PROJECT NO. PR-2021-005687
Application No. SI-2021-00985

SUBMITTAL DESCRIPTION: Updated plan set, paving plan, memorandum addressing all comments from transportation

Memorandum

To: Ms. Jeanne Wolfenbarger, P.E., Development Review Board
From: Jim Strozier, FAICP
Date: April 22, 2022
Re: Response to PR-2021-005687 Transportation Comments

E X H I B I T ' A '

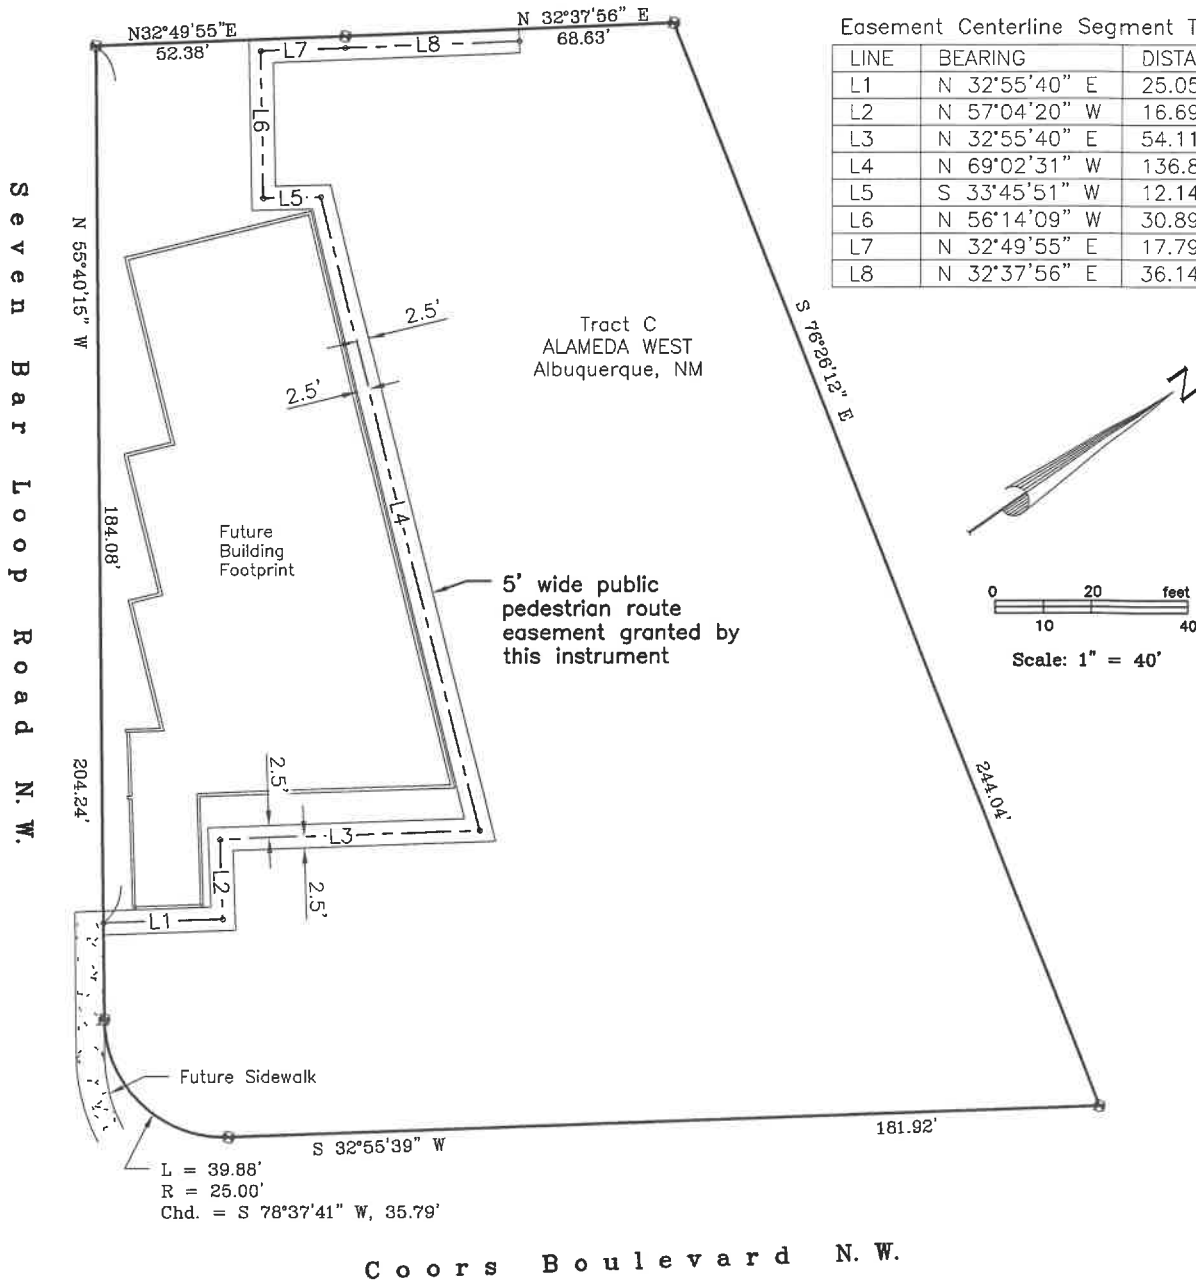
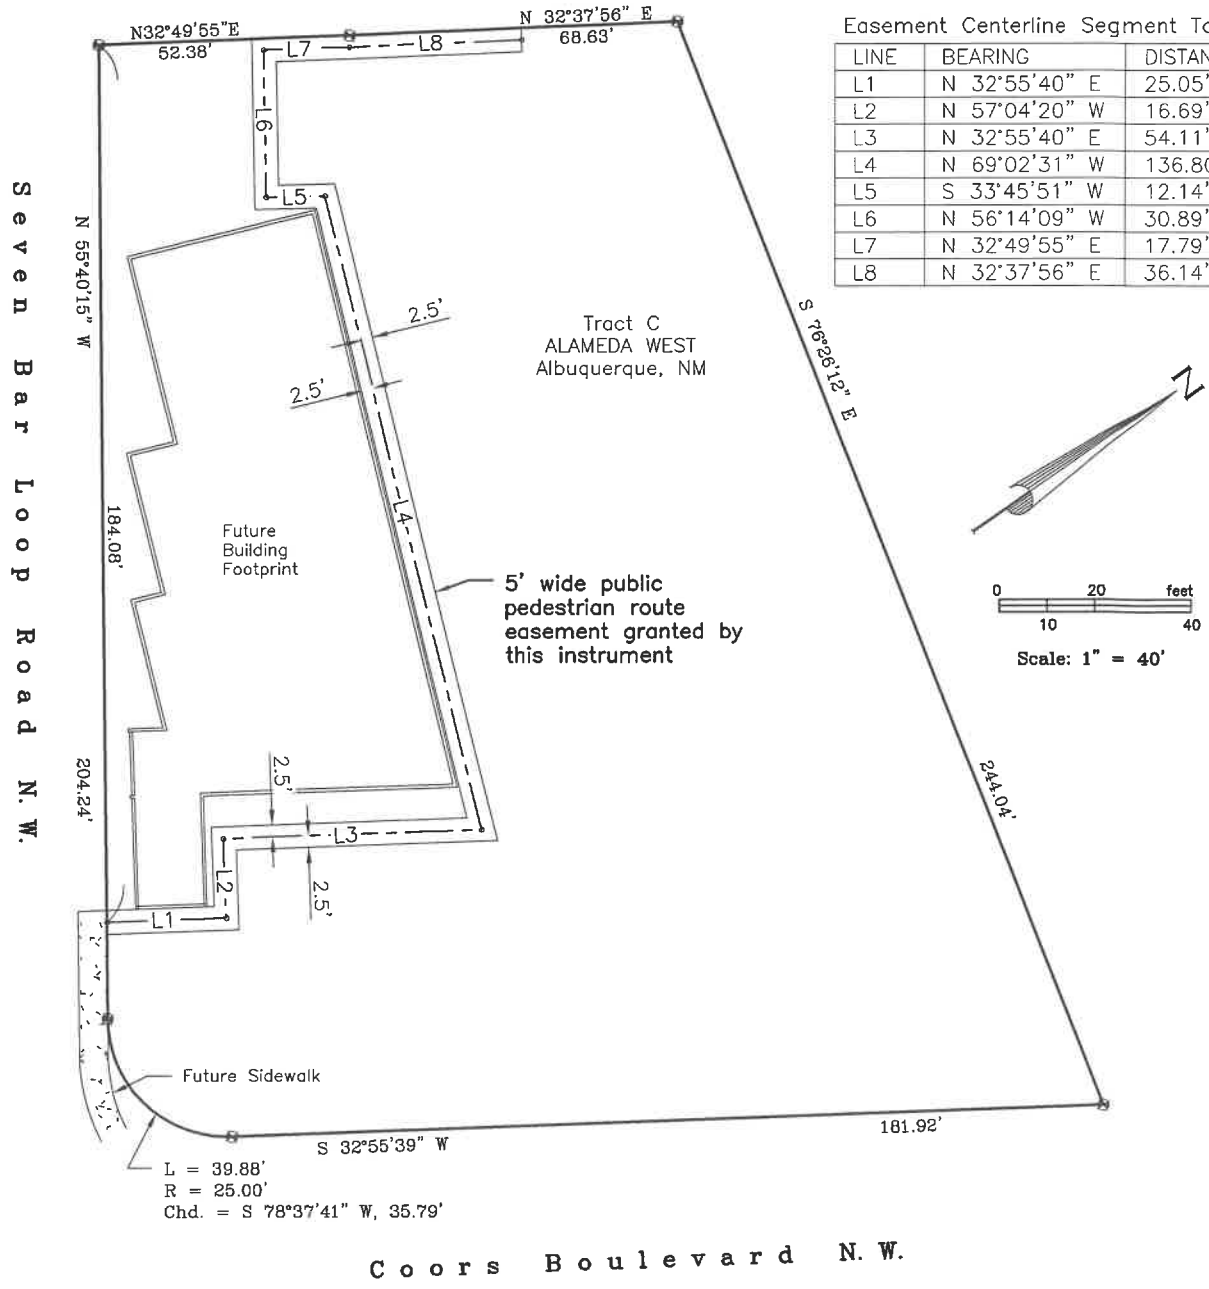
What does the 30-foot dimension represent on the plan view to the north of the site? (Any easements should be shown clearly.)

PAINTED CROSSWALK AND ACCESSIBLE RAMPS

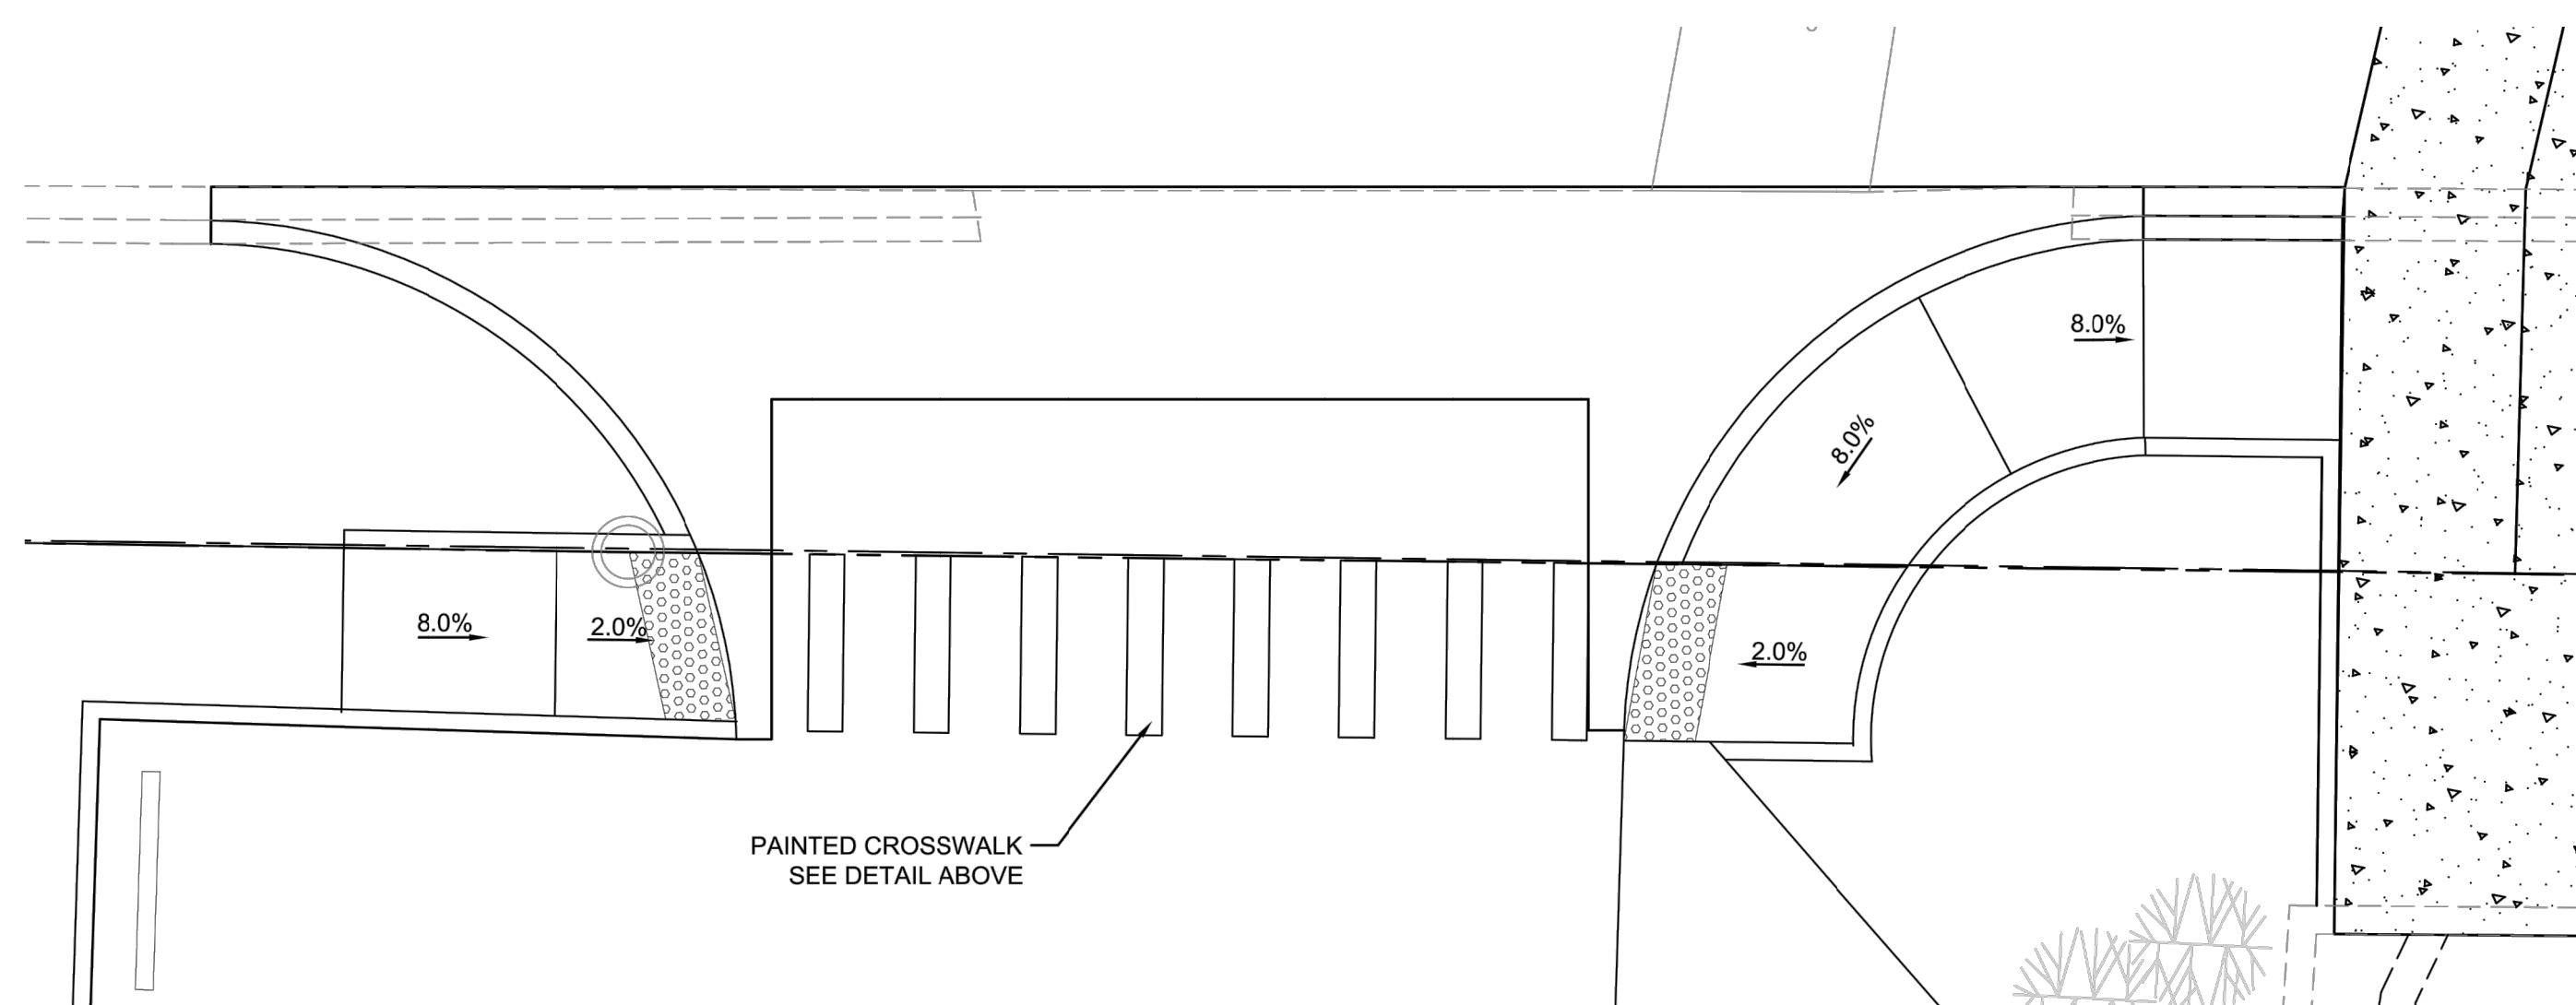
Designate all curb ramps on the site plan with a keyed note and include ramp details on the civil sheet along with the detail of the crosswalk.
